The following are my views and comments on the current scheme issued by Green Hill Solar and reasoning why this Application should be rejected.

[2] Environmental Statement: Chapter 15: Glint and Glare

Title:  
Figure 16.4 BESS Fire Emissions Study Area,  
Receptors and Modelled BESS Locations

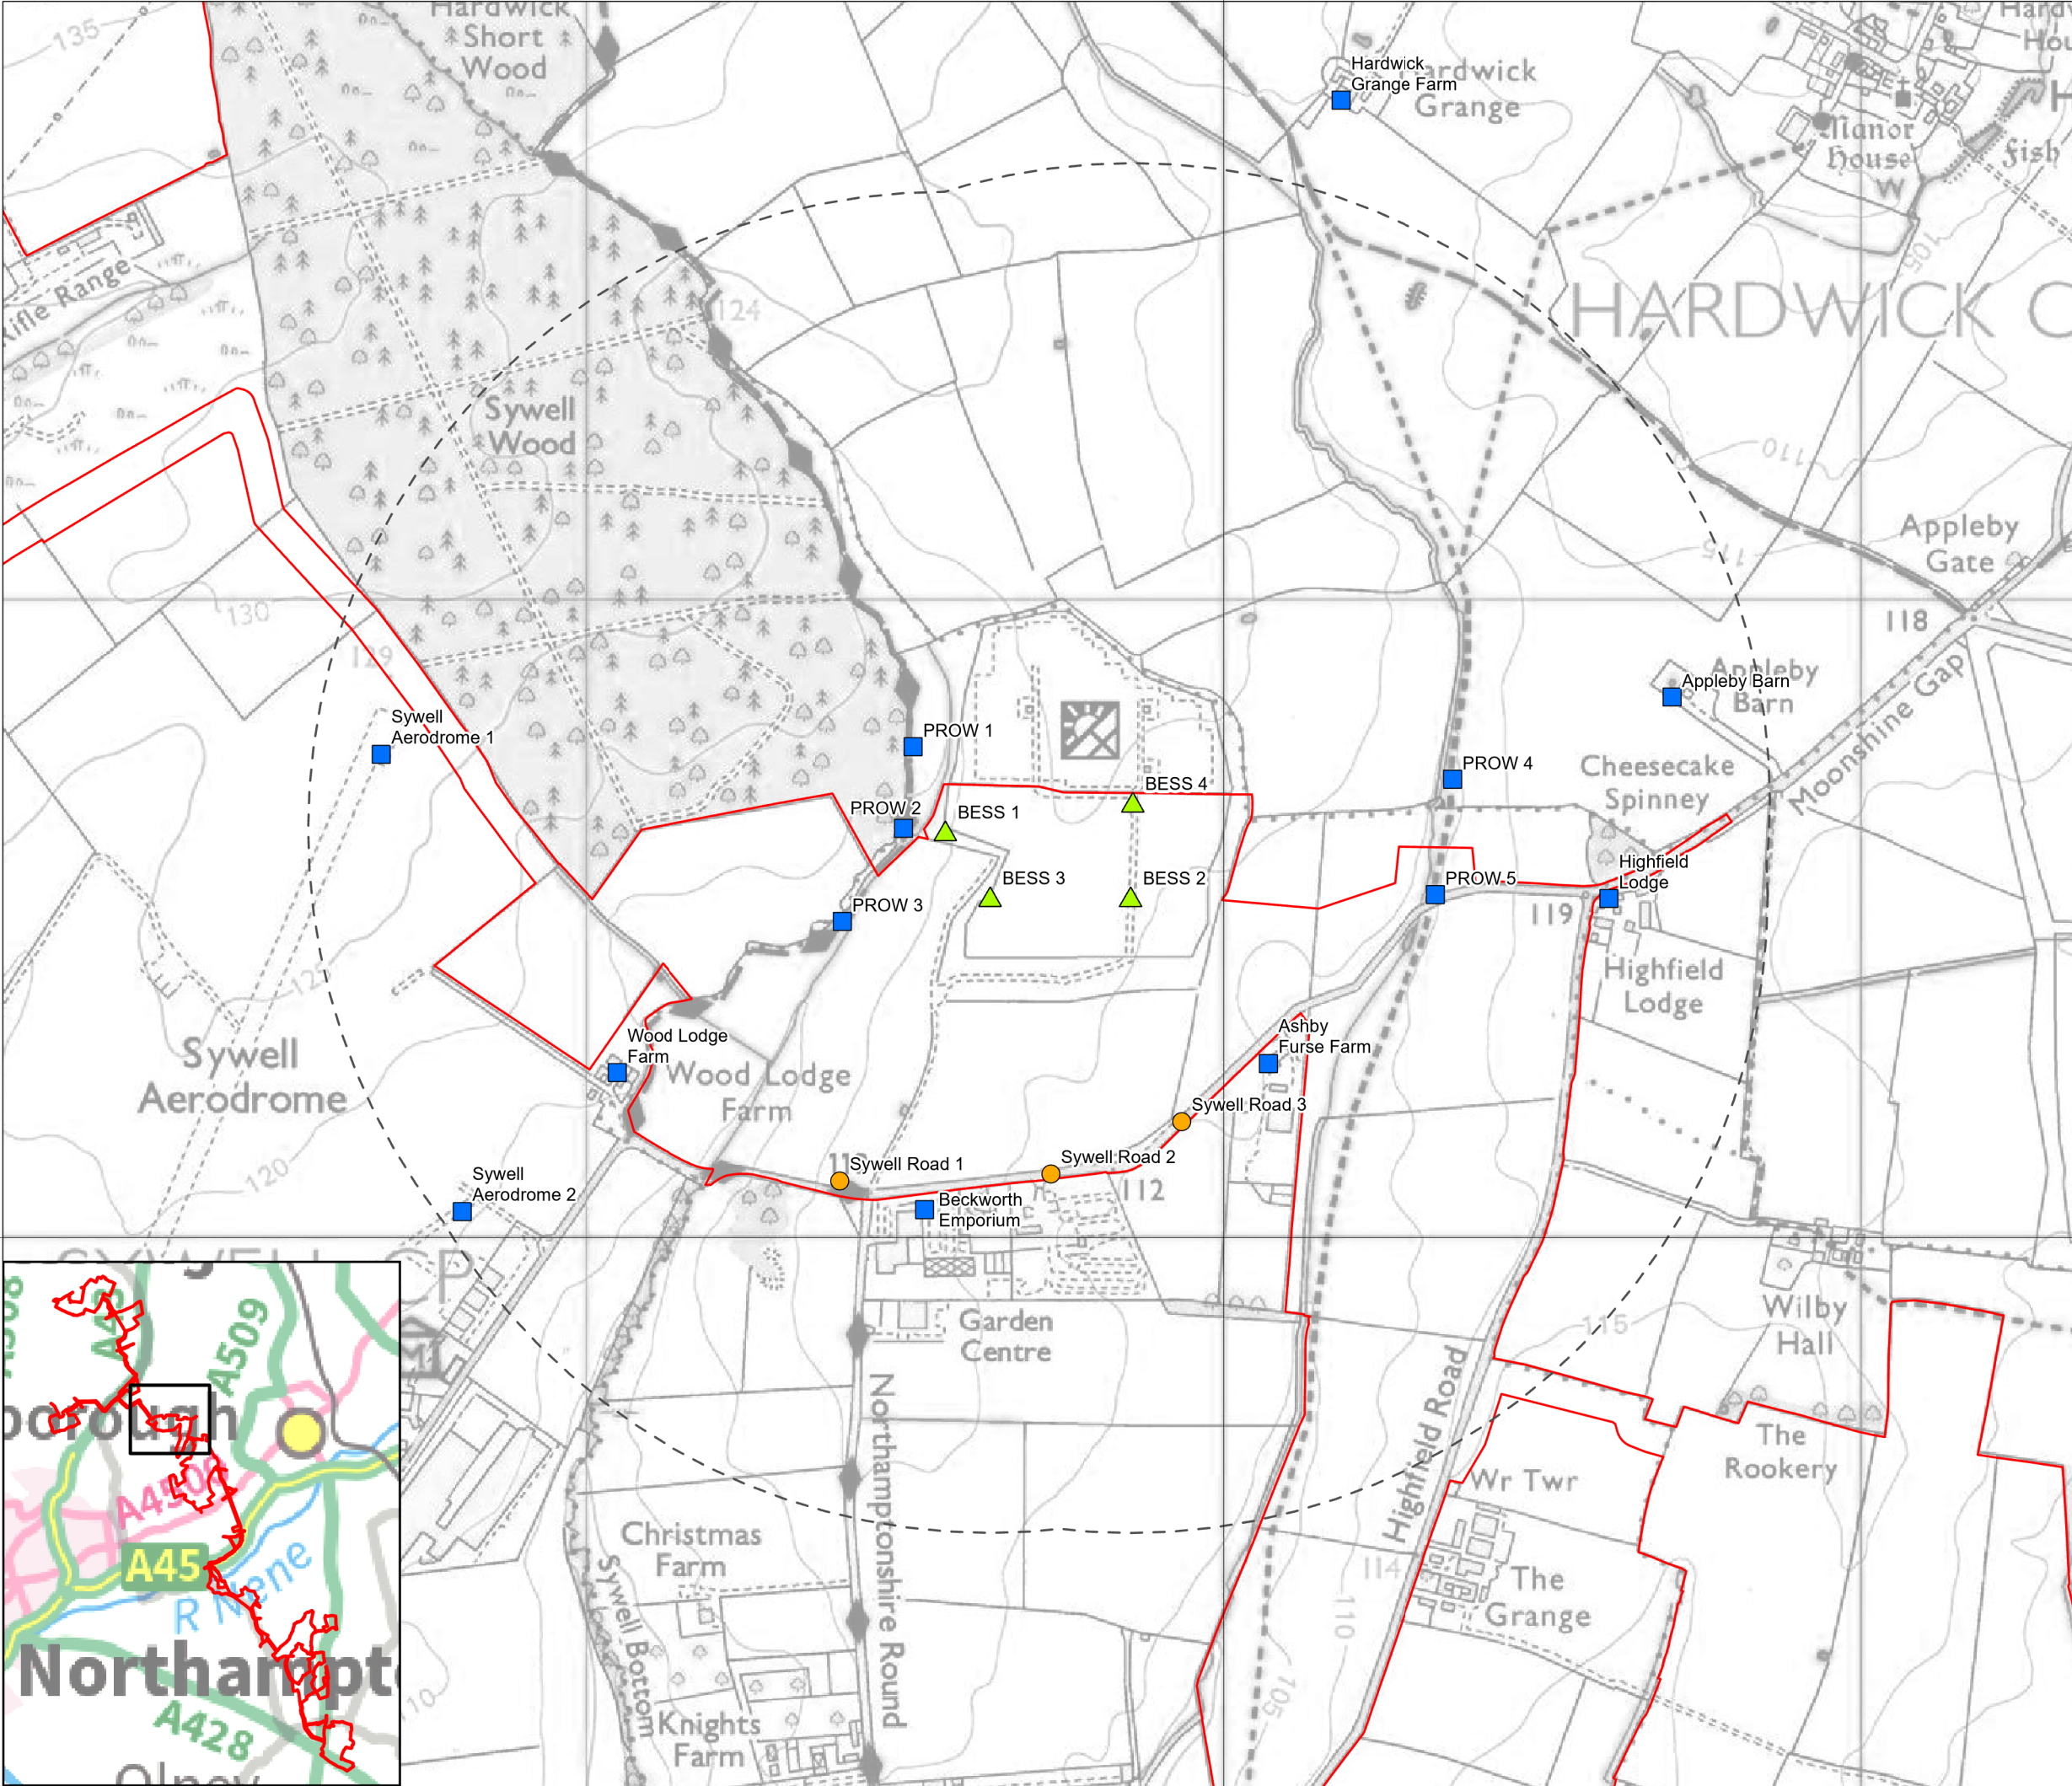
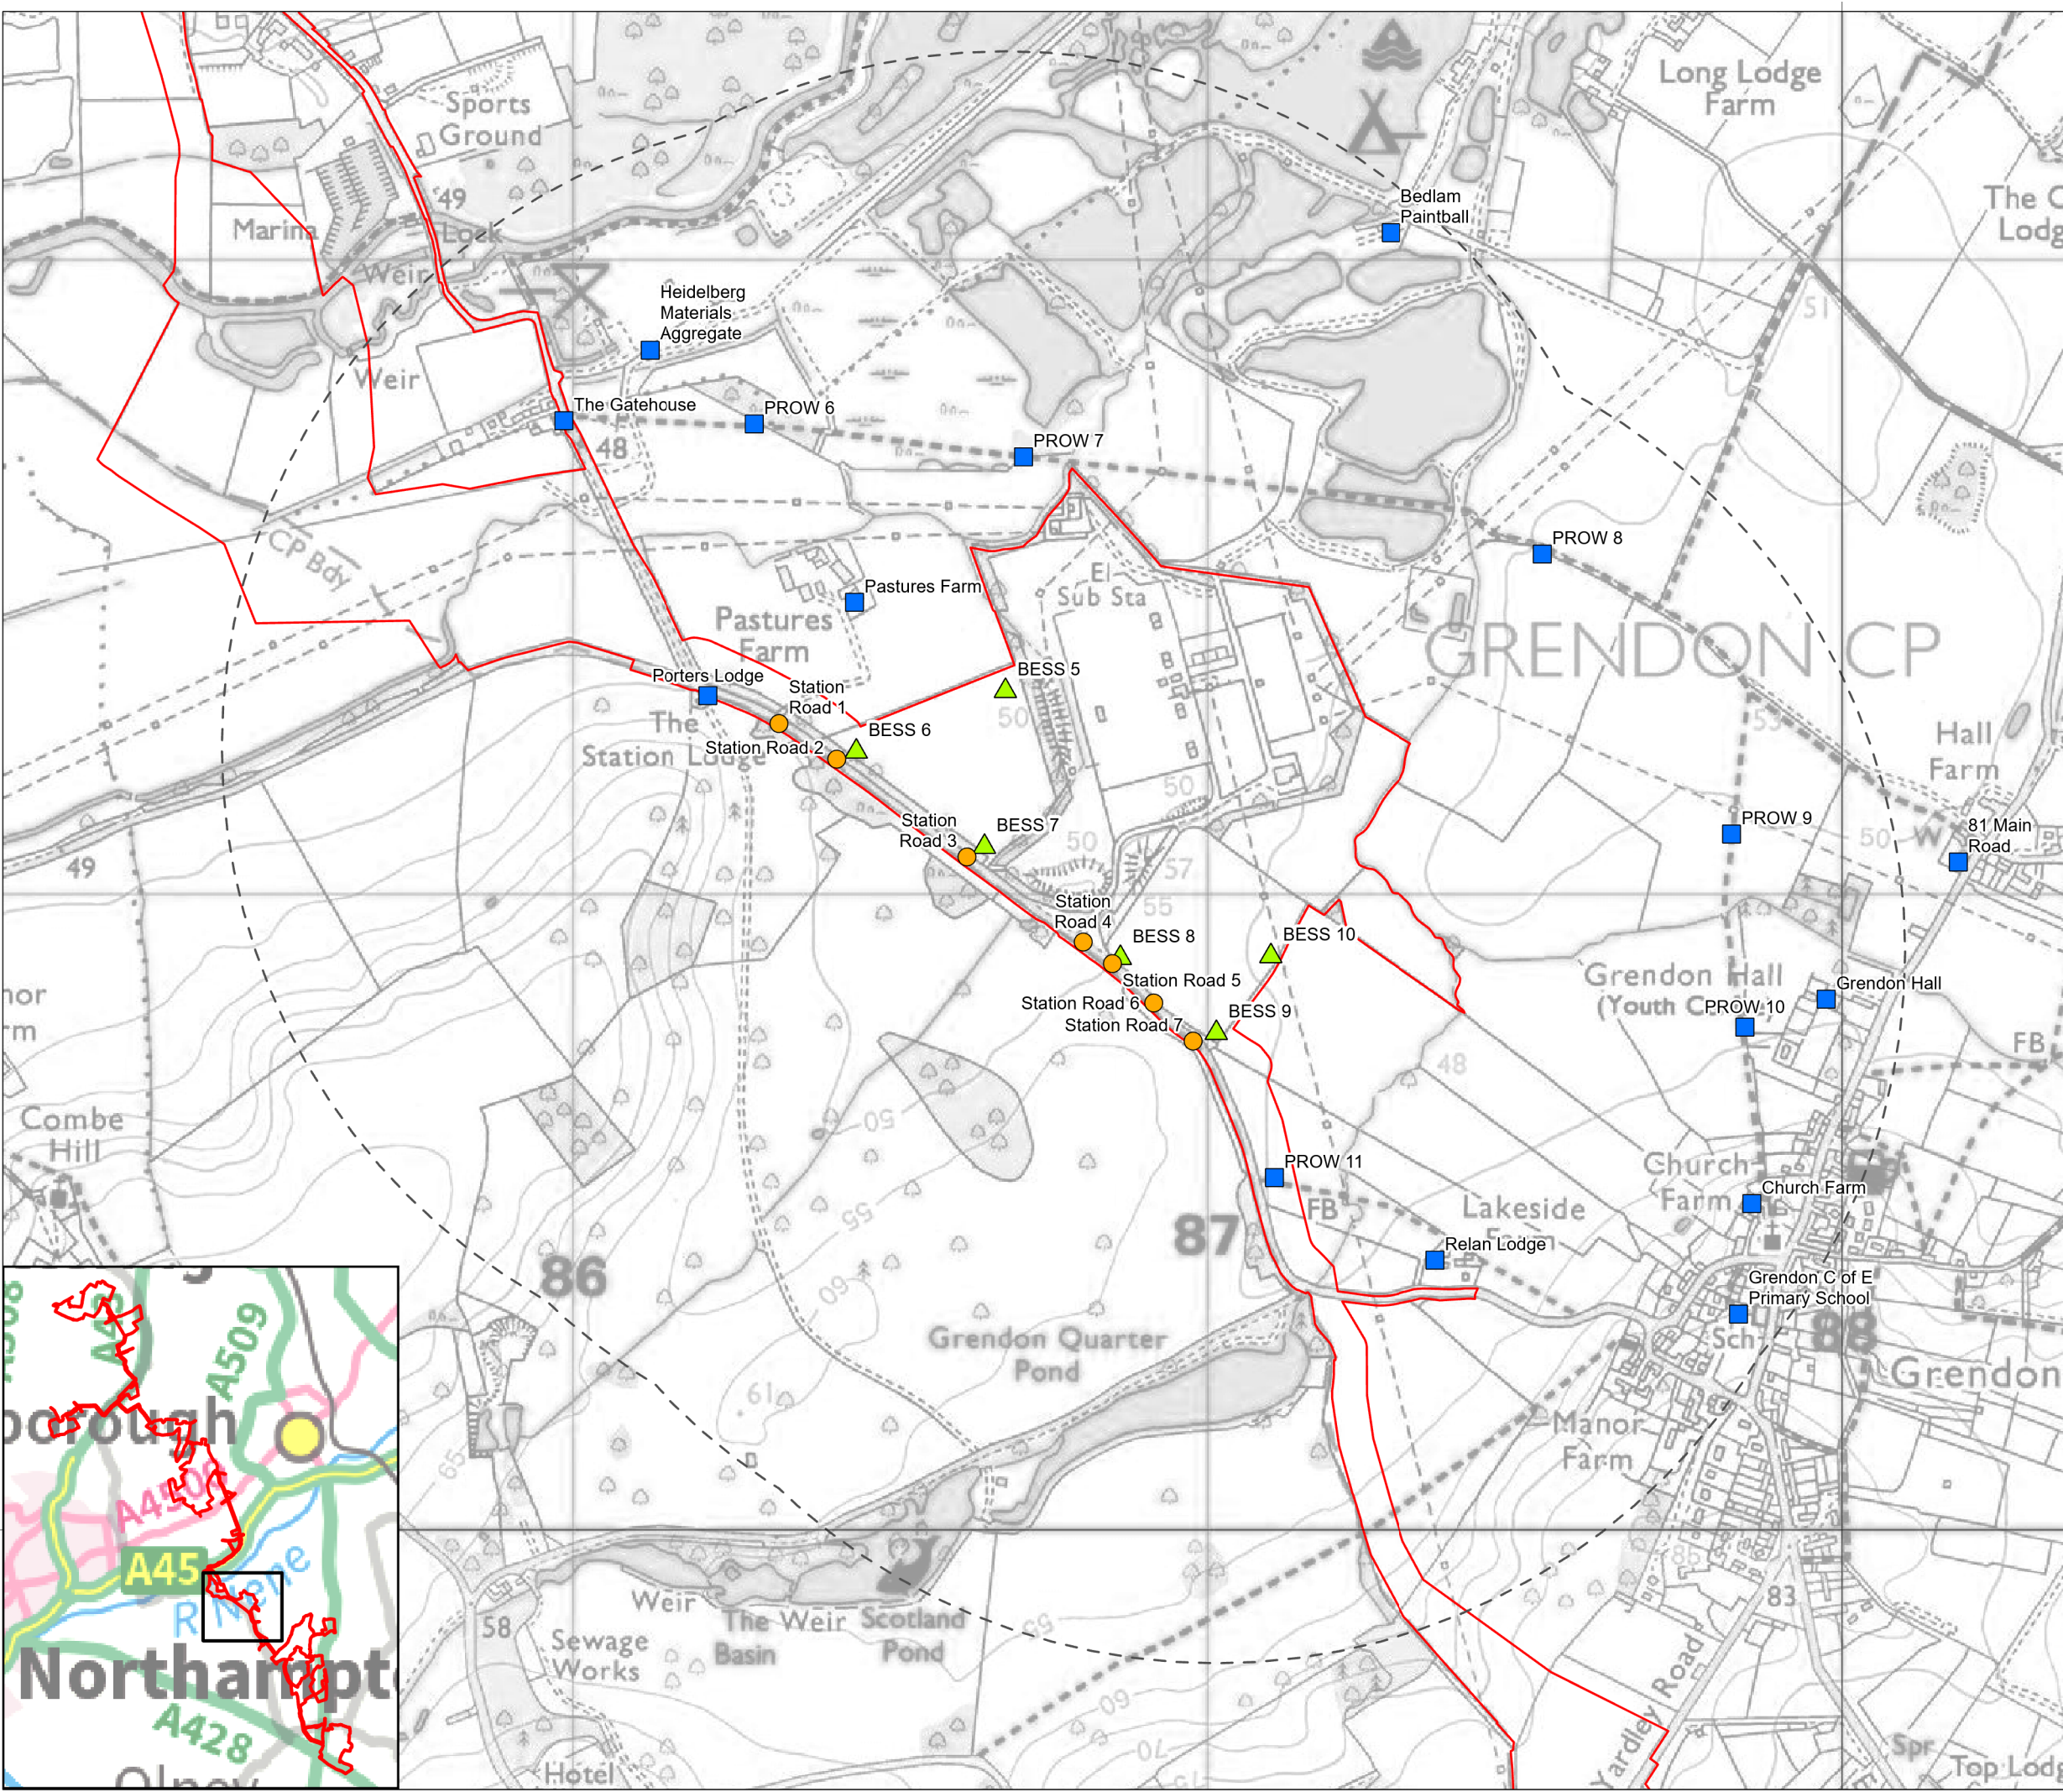
These 'state of the art' control systems singularly failed to mitigate the 'thermal runaway' fire incident. Local residents were evacuated due to the toxic fumes being emitted and the fire authorities took up to 24 hours to bring the fire under control. The nearest housing in Grendon to the proposed BESS is only 300 metres distance.

This part of the country mainly experiences winds originating in the south-west/ west-south-west direction. Toxic fumes from a fire will have an impact on areas of Grendon and local farms. As an example a fire at the San Diego BESS [August 2024] resulted in properties and businesses being evacuated up to a mile from the facility and affected up to 500no businesses. It took emergency services 48 hours to bring the fire under control.

There is no ‘Emergency Response Plan’ included in the Application that would be implemented in the event of emergency incident at the BESS plant. As an example, during the August 2024, ‘thermal runaway’ incident at the San Diego BESS installations, the toxic emissions resulted in the forced evacuation of houses and businesses up to a mile away from the plant as it took emergency services 48 hours to bring the fire under control.
